**From:** Elliott, Stanice  
**Sent:** Friday, March 17, 2017 10:48 AM  
**To:** 'Dan Lyons'  
**Cc:** Cordova, Camille C.; Miranda, Rachel; Sandoval, Darlene M.; Blocker, Lois  
**Subject:** RE: Catholic Charities - 2010 Bridge Blvd. SW - Hydrology Temp. Extension

**RE: Catholic Charities  
2010 Bridge Blvd  
Request 90-Day Temporary C.O. - Accepted  
Engineer's Stamp Date 11-11-15 (File:L12D012)  
Certification date: 12-22-16**

RE: **Catholic Charities**  
**Grading & Drainage Plan**  
**Engineer's Stamp Date (11-11-15) (File: L12D012)**

RE: **Catholic Charities**  
**Conceptual Drainage Plan for Site Development for Building Permit**  
**Engineer's Stamp Date (none) (File: L12D012)**

C-101

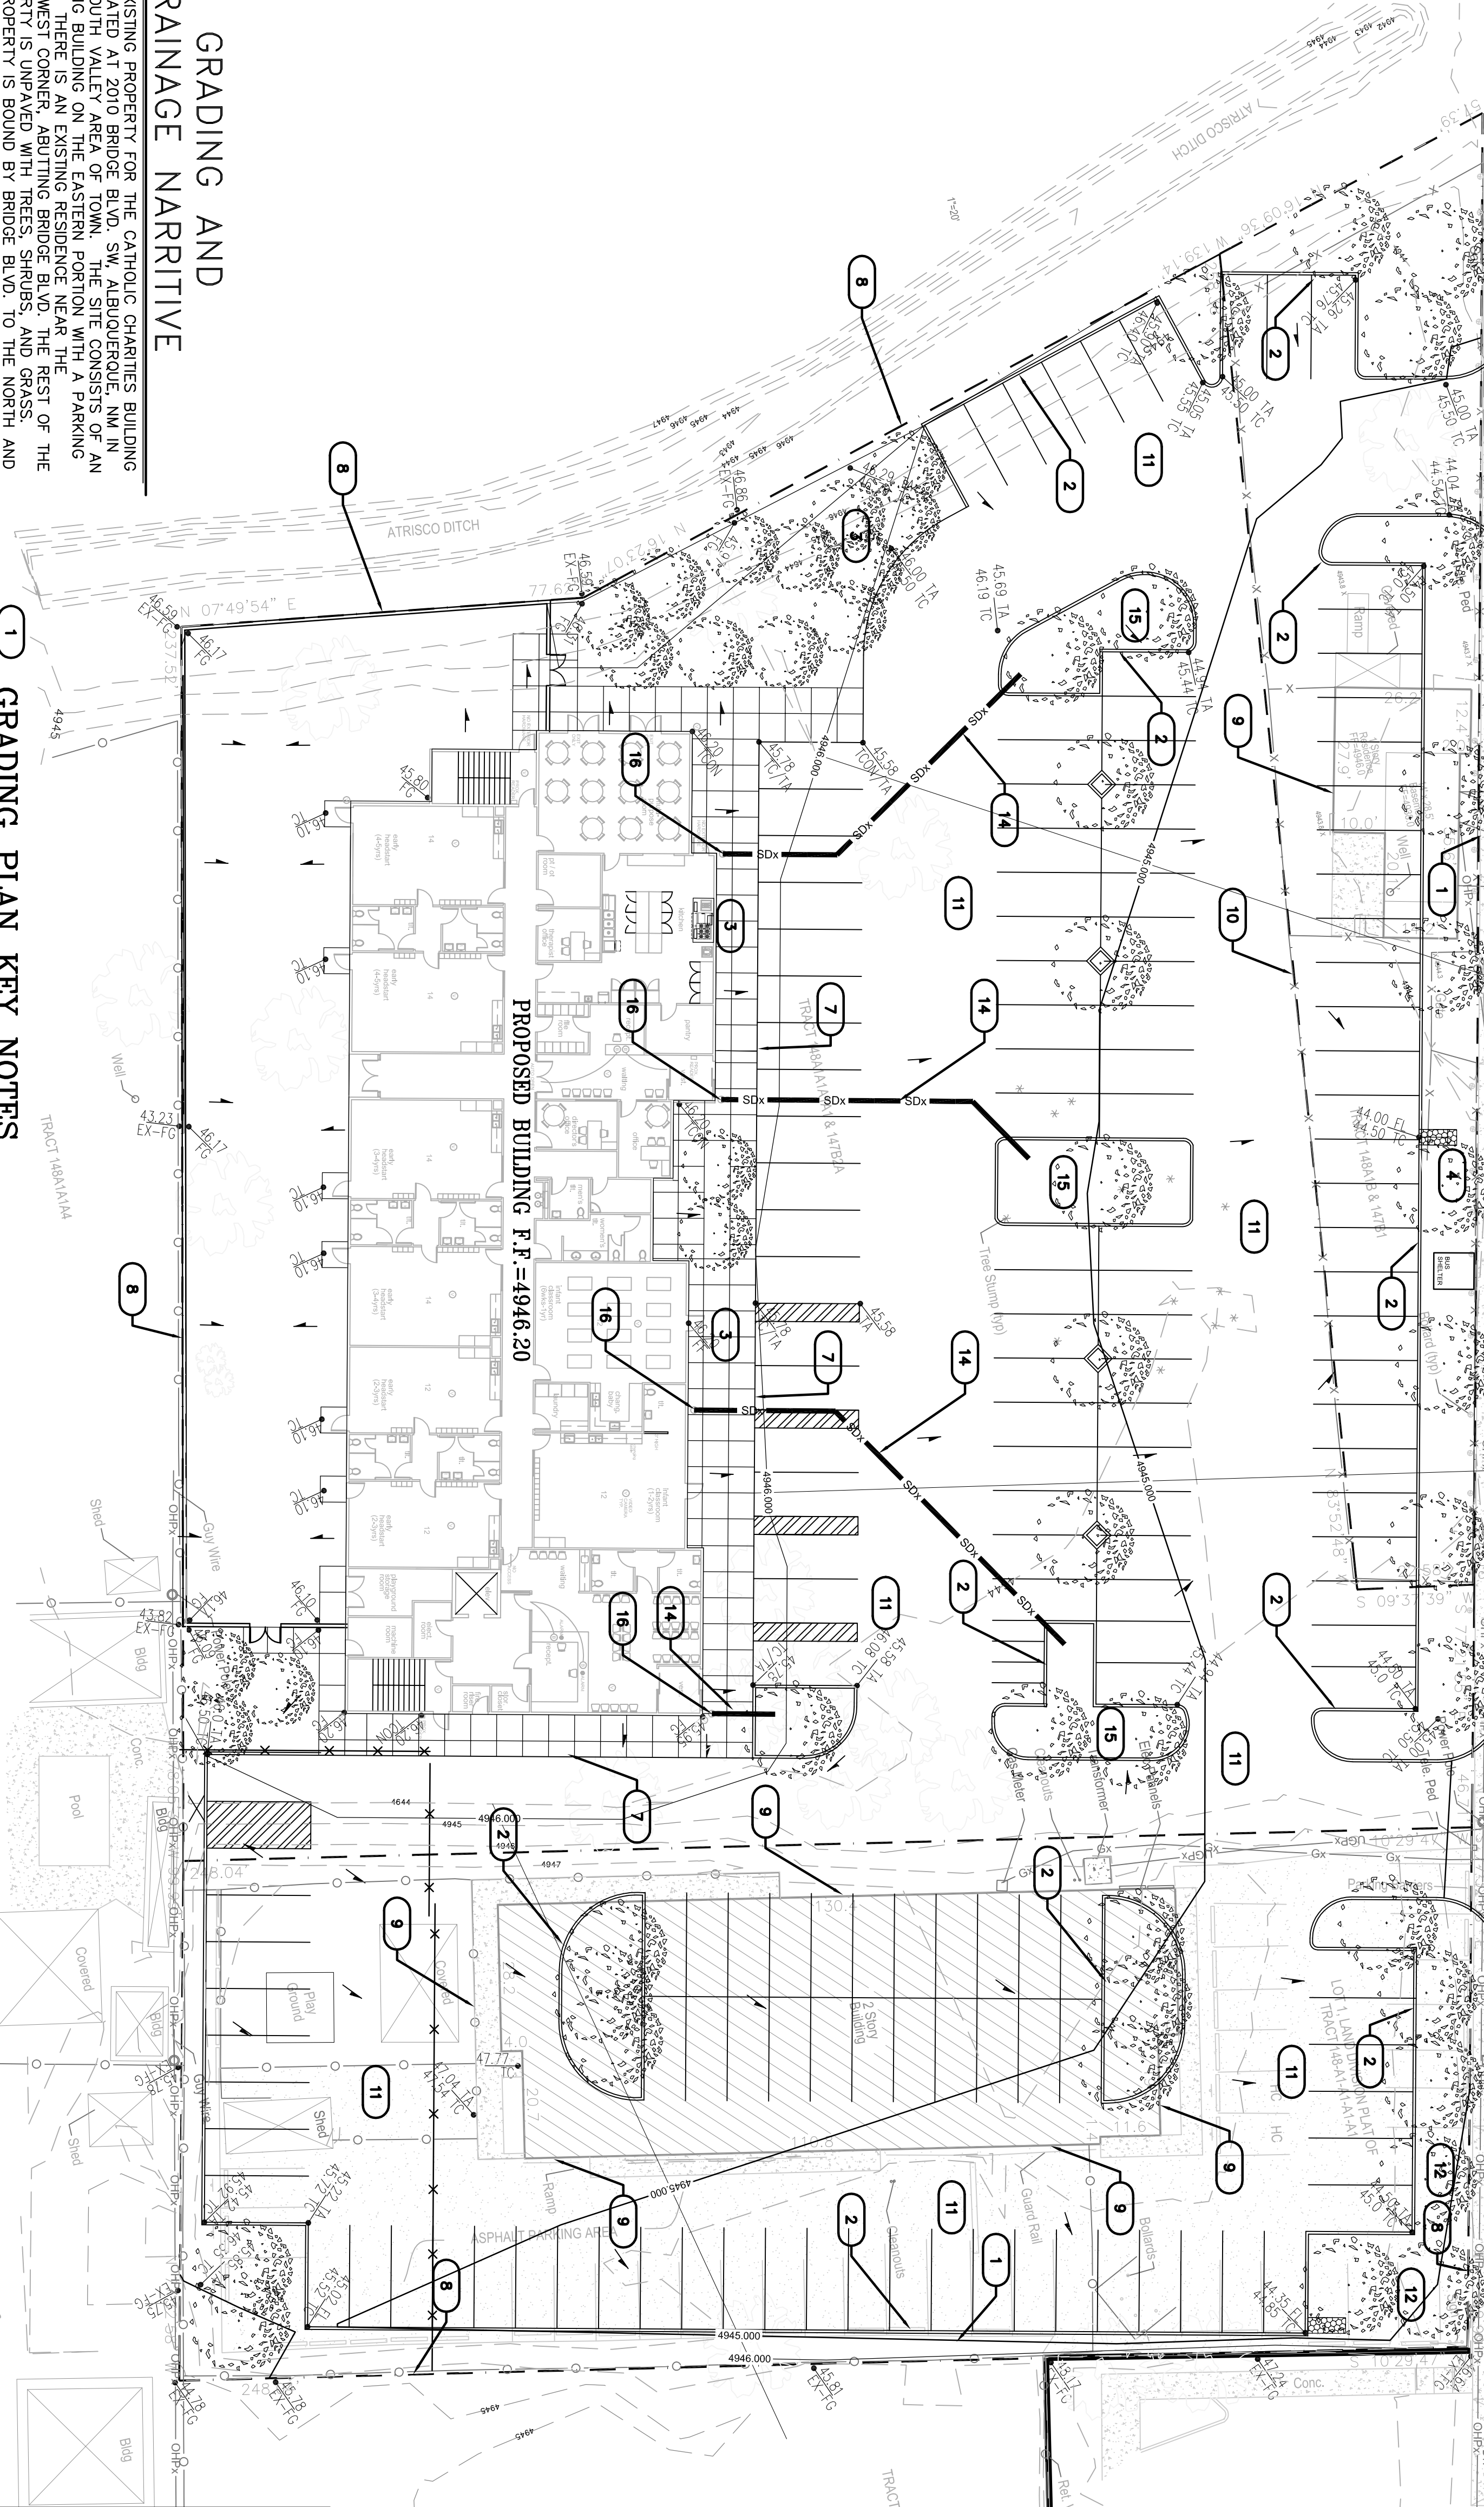
1. The proposed bus shelter must be moved out of the water harvesting/First flush pond.
- 2. According to Racquel Michel, the architect is aware that a TCL is required for Building Permit. Flowline elevations at the Curb returns need to match that shown on the TCL.
3. Do not extend the Sidewalk Culverts 2' into the ponds. Terminate them at the back of sidewalk.
4. Add a note to tack weld the plates on the sidewalk culvert to the bolts.

- ✓ 1. Runoff calculations, pond volume calculations, and "First Flush" calculations need to be provided.
- ✓ 2. The Vicinity Map and FEMA FIRMette should be on the Conceptual plan. Include on the Building Permit G&D plan.

- ✓ 3. Show Bench Mark
4. Show and call out all curb cuts, particularly on the 2 main ponds south of Bridge.
5. Call out Rip-Rap
6. Provide more TA , TS, and TC elevations to better understand the drainage around the building.

7. Show TC elevations of high and low side of curbs around water harvesting ponds.
8. Show Roof Flow arrows. Does any roof flow discharge to the south?
9. Roof Storm Drain pipe at NE corner of building extends to water harvesting pond closer to the building. Call out this area as a Water Harvesting Pond.

10. All Parking Islands and landscape islands which are used for Water Harvesting need to have contours and elevations so that they are constructed as such. State that any landscaping rock should be below these elevations.

11. How will area on South side of building drain?
12. In the narrative, use "first flush" rather than " 90<sup>th</sup> percentile..."
13. Keyed note 13 is not shown on the plan. Show SW culverts. Show or state that plates are to extend out 2 ft, and bolts to be tack welded to the plate.

14. If work in the ROW is to constructed per SO-19 Permit, then be sure SO-19 Notes are on the G&D plan. Include "SO-19" in the Title for the construction notes as well as a signature block for the Street Maintenance Inspector.

16. Curb returns need to be detailed on the Grading plan since it is not going to be reviewed in the DRC/Work Order Process.
